Our Case Number: ABP-313182-22

Re: BusConnects Clongriffin to City Centre Core Bus Corridor Scheme
County Dublin

RE: Objection to Application for Approval of a Proposed Road - CLONGRIFFIN TO CITY CENTRE CORE BUS CORRIDOR SCHEME – at Artane Cottages Lower, by the National Transport Authority, Case Ref. HA29N.313182

Figure 34a: Island Bus Stop Arrangement with 2-way cycle track

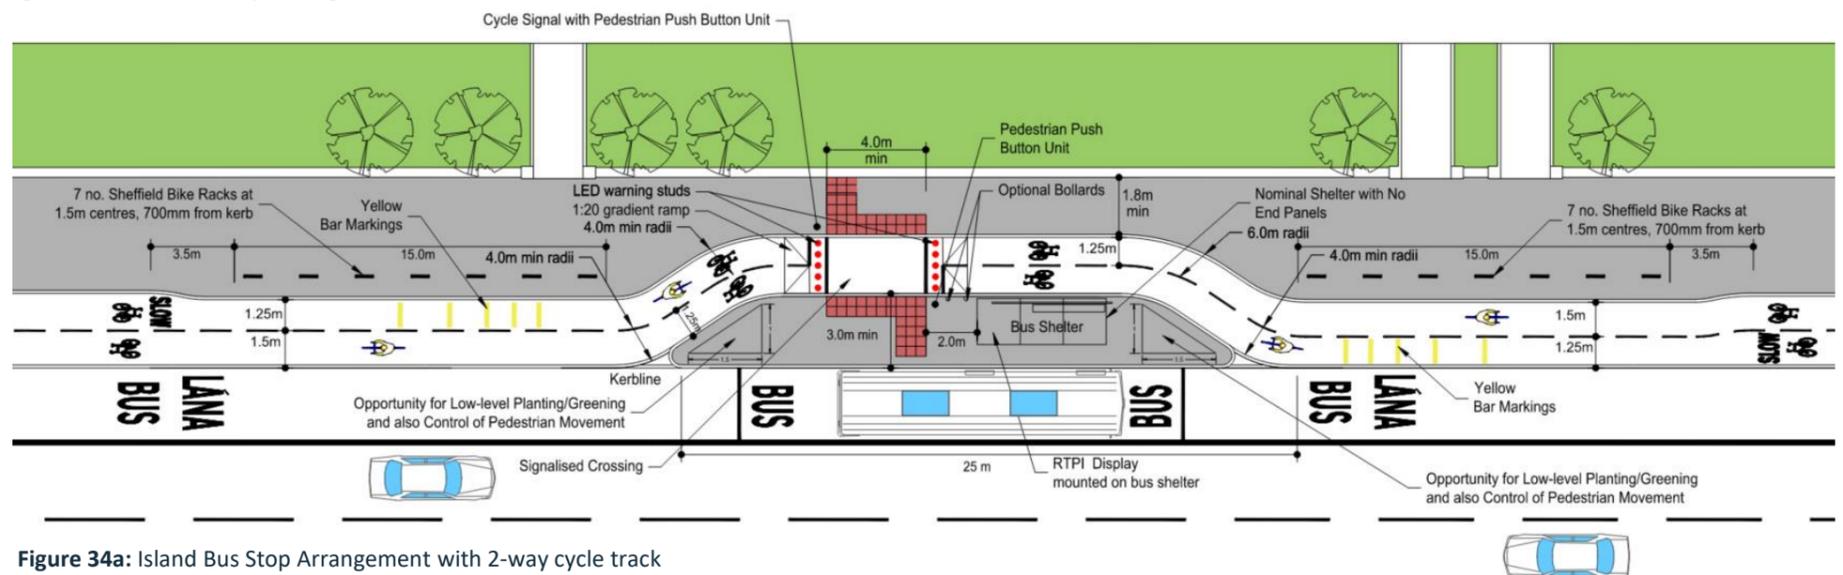
As acknowledged indirectly by the NTA Oireachtas Liaison statement at section 3., the proposed bus stop design at Artane Cottages Lower contravenes NTA's own in-house Design Guidance. It also goes against minimum requirements as established by Irish cycling and universal accessibility interest groups.

"Island Bus Stops are the preferred bus stop option to be used as standard on the CBC project where space constraints allow." (11.1 Island Bus Stop)

An Island Bus Stop crucially includes a 3m deep island, which provides movement space in excess of 2x2m, a full bus shelter and tactile paving at a designated signalled pedestrian crossing over the 1.5m cyclepath. At Artane Cottages Lower, with the NTA commitment to provide a full width (3.5m) footpath as existing, this would require a min. 8m deep zone between front walls of the cottages and the bus lane.
